**Development Application and Planning Proposal Review
NSW Planning Portal Concurrence and Referral**

Authority	Authority's Reference	Agency Concurrence and Referral	Authority Contact	Authority Notification	Submission Due	Submission Made
NSW Dept. of Planning & Environment	SSD-57064458		Patrick Nash	14/09/2023	12/10/2023	18/09/2023

Address	Land Title
50 & 86 DUNMORE ROAD DUNMORE 2529	Lot 10 DP 1281639

Environmental Impact Statement (EIS) for the New Shellharbour Hospital. Construction and operation of a new hospital development including landscaping, internal roads and access, at-grade and multi deck car parking, utility / service connections and supporting infrastructure.

Site Plan from Endeavour Energy's HxGN NetWorks Core NetViewer Master Facility Model

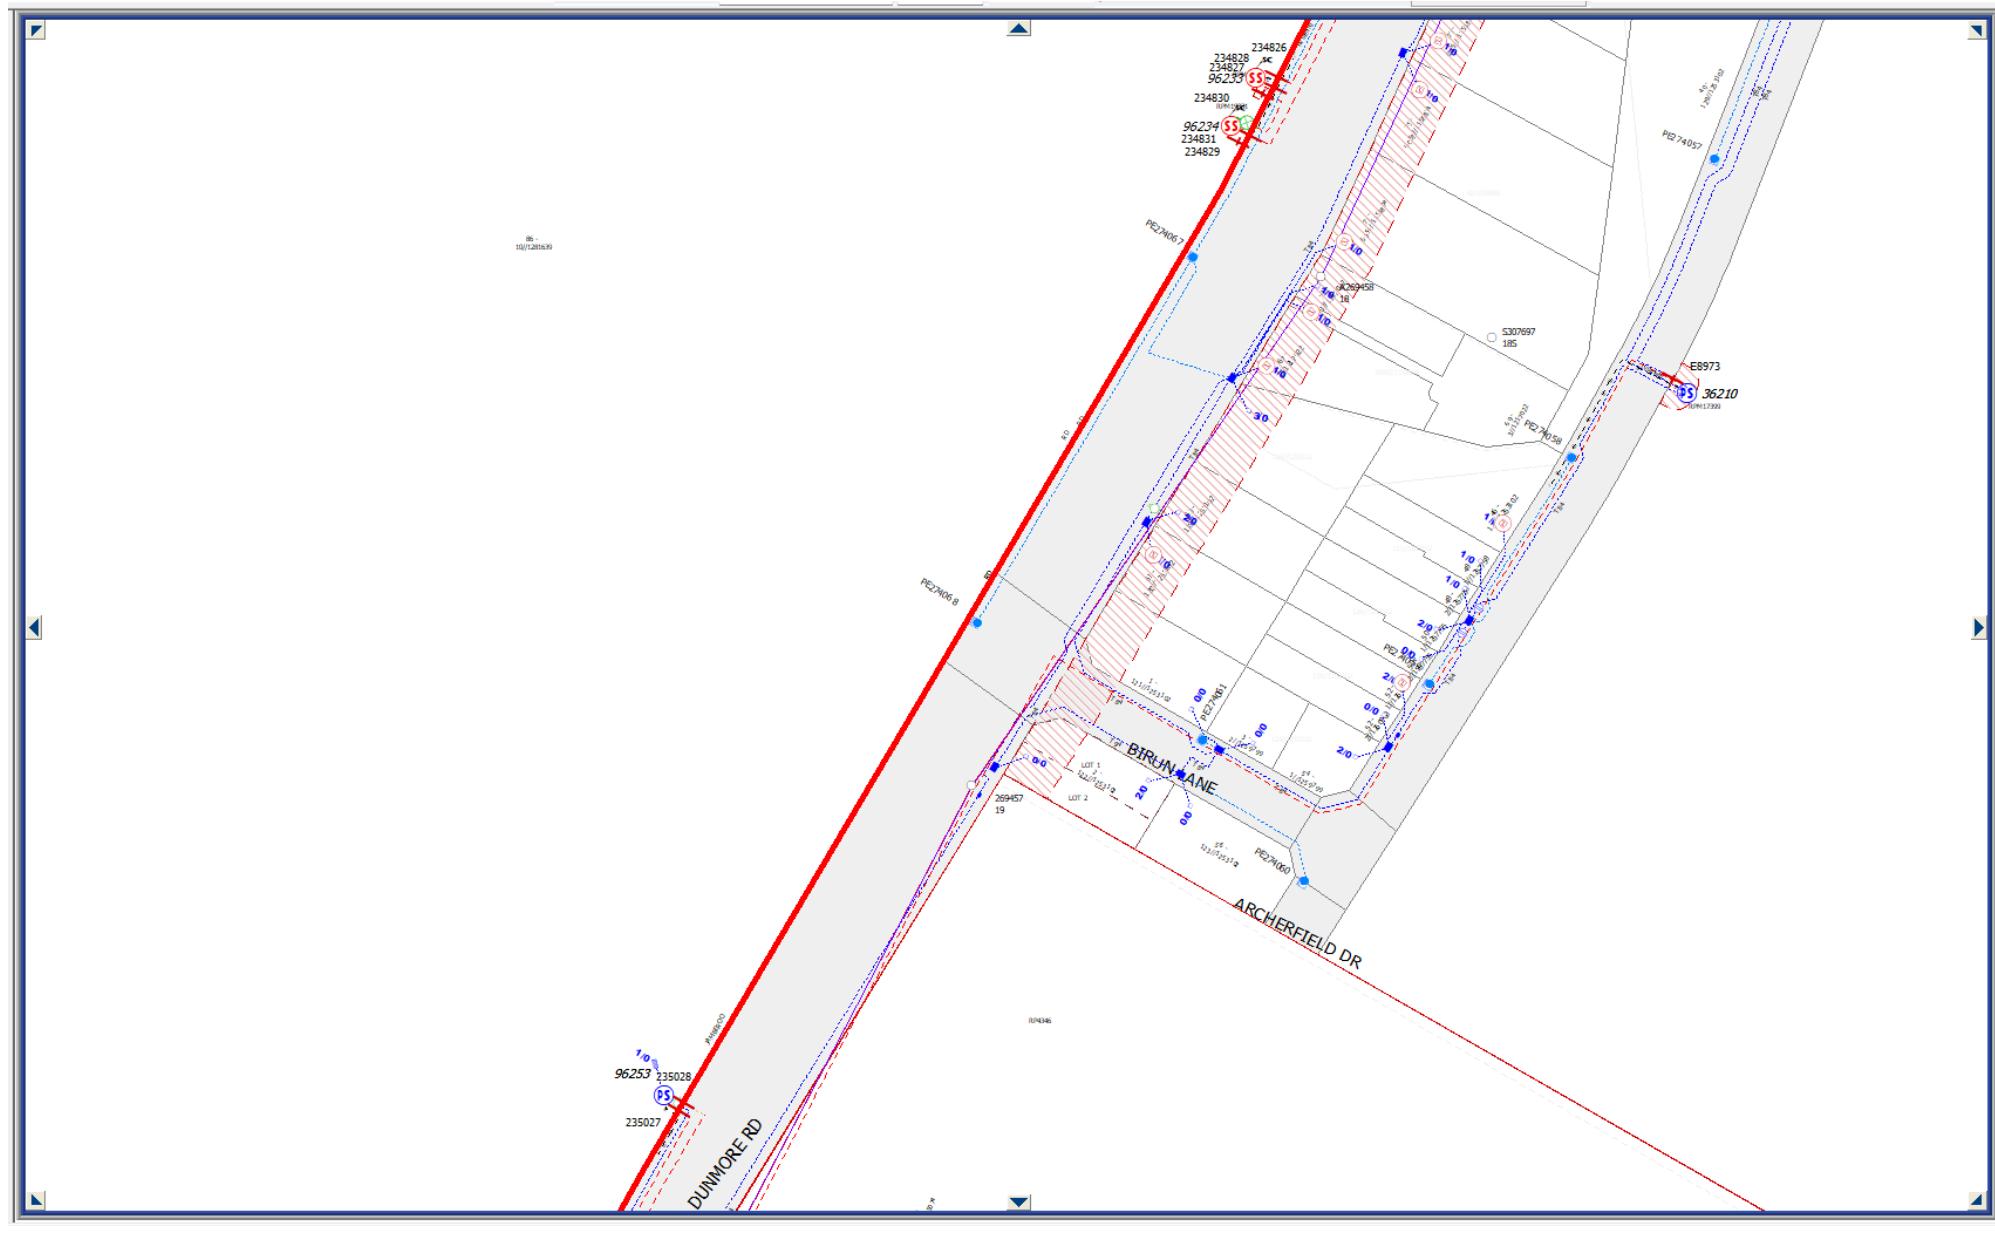
- Electricity distribution infrastructure on private property over which there is no easement are regarded as protected works under Section 53 'Protection of certain electricity works' of the *Electricity Supply Act 1995* (NSW) and may be managed as if an easement is in place.

Endeavour Energy's Mains Design Instruction MDI 0044 'Easements and Property Tenure', Table 1 'Minimum easement widths' requires a minimum easement width of 9 metres for low voltage up to 22,000 volt / 22 kilovolt (kV) high voltage overhead power lines ie. 4.5 metres to both sides of the centreline of the poles / conductors.

- The Site Plan from Endeavour Energy's G/Net Master Facility Model shows the existing overhead power lines on and near the site are 'Proposed removed' (indicated by the  colouring).

Site Plan Proposed

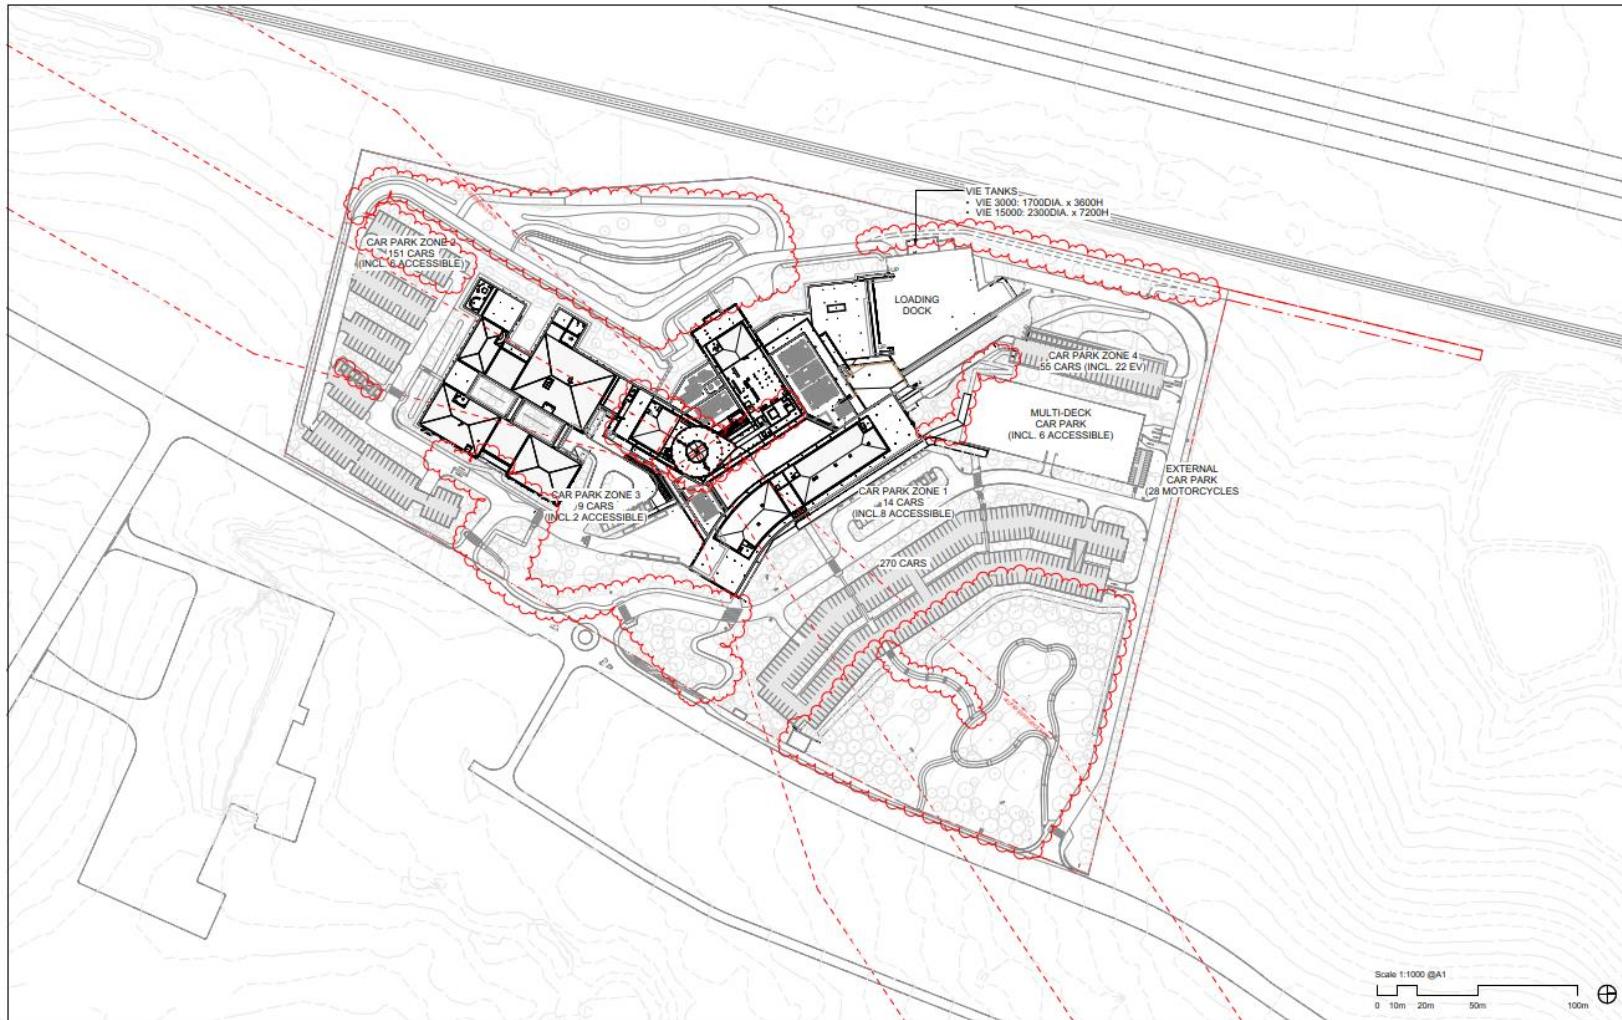
The proposed Endeavour switching stations and hospital private high voltage main switchboard shall be situated at the boundary of site to avoid Endeavour Energy easements encumbrances. This significantly reduces planning constrains for future developments on the site.

The proposed Endeavour switching stations and hospital private high voltage main switchboard shall be situated at the boundary of site to avoid Endeavour Energy easements encumbrances. This significantly reduces planning constrains for future developments on the site.
